KITTITAS COUNTY

MEMORANDUM

TO: Community Development Services
FROM: Taylor Gustafson
DATE: September 14, 2018
SUBJECT: Review of BLA BL-18-00010 (Carney)
** CDS Refers to this as #6 LLC

DRAWING TYPE: RECORD OF SURVEY

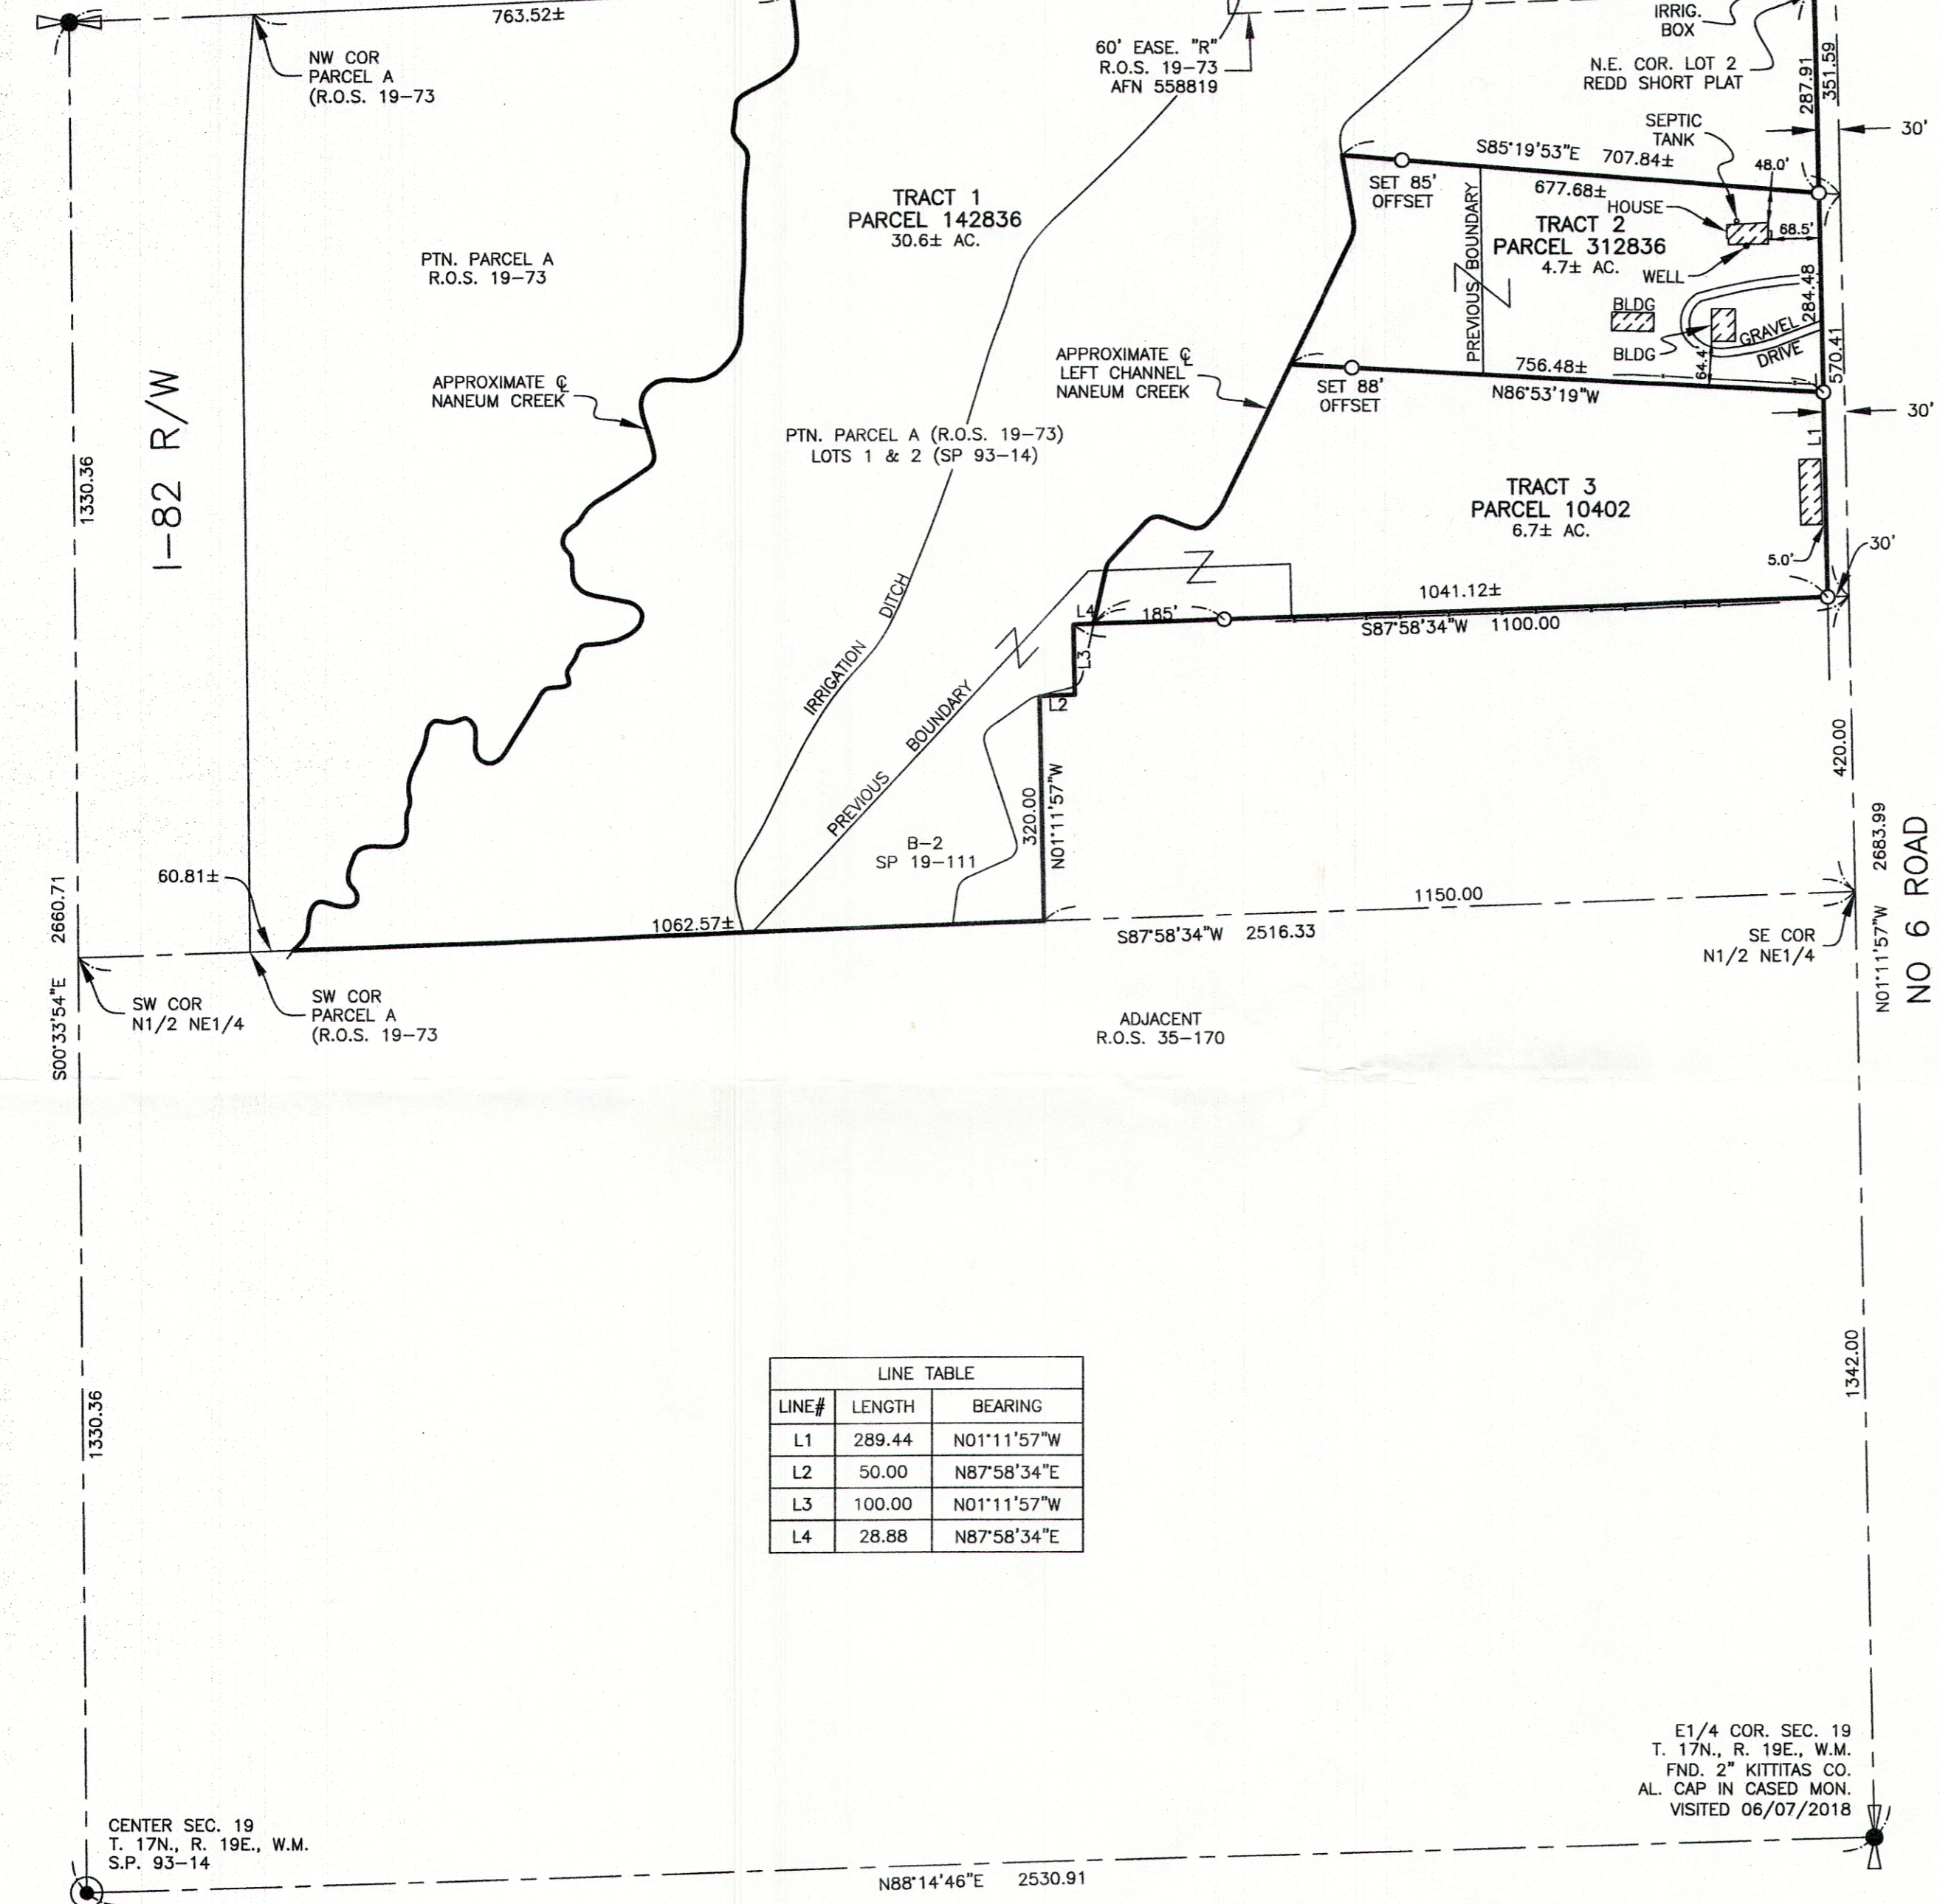
1. No. 6 Road, in this location, is classified as a Rural Minor Collector with a requirement for 300' spacing between access points. Please provide detail in regards to how this requirement will be met through this BLA

1. Basis of Bearing labeled or noted. (WAC:332130-050(1))b(iii))

2. All roadways should show name, width, underlying ownership and surfacing material.
Ex. No. 6 Road (60' County R/W – Paved) (or similar)
3. A Purpose of Survey statement shall be included (KCC 16.10.020(1))
Ex. The purpose of this survey is to illustrate and delineate the parcels shown hereon to facilitate the application for Boundary Line Adjustment BL 18-00010.(or similar)
